pping to Thornleigh Third Track Proposal. Application number SSI 5132.

/we object to the Epping to Thornleigh Third Track Proposal and consider that the EIS is inadequate and does not address the full impact of this proposal. It will cause untold damage to the health of residents and to the fabric of the Beecroft Cheltenham Heritage Conservation Area. Do not approve this project, reconsider the alternatives and protect the community.

Figure S.5 Artist's impression of new elevated concourse at Cheltenham Station looking south from The Crescent (indicated by dot)

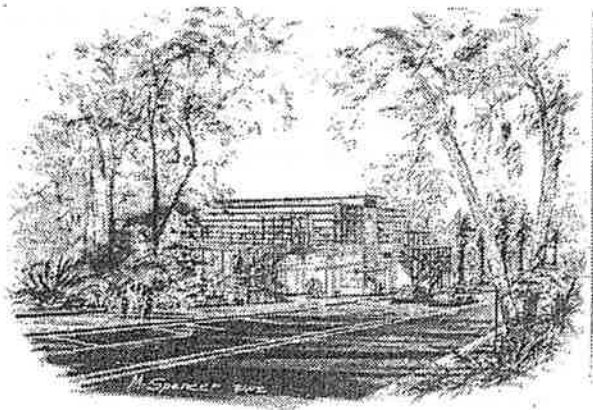
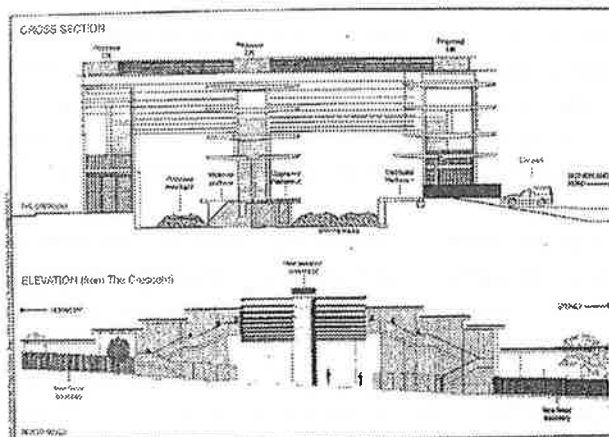
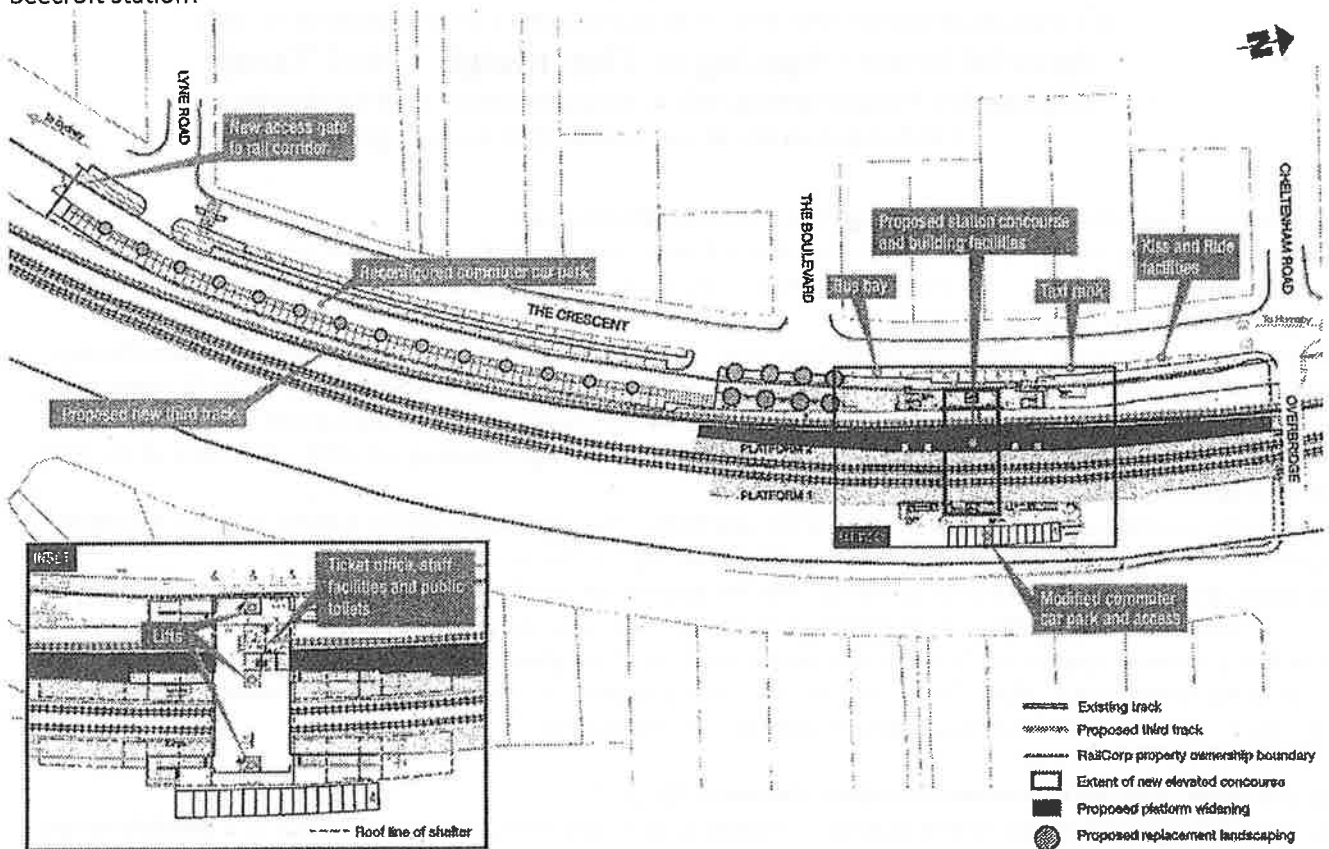
- The proposed redevelopment of Cheltenham Station shows no regard for the HCA. The visual impact of the proposed 13m high glass and steel concourse is totally unacceptable in this HCA.
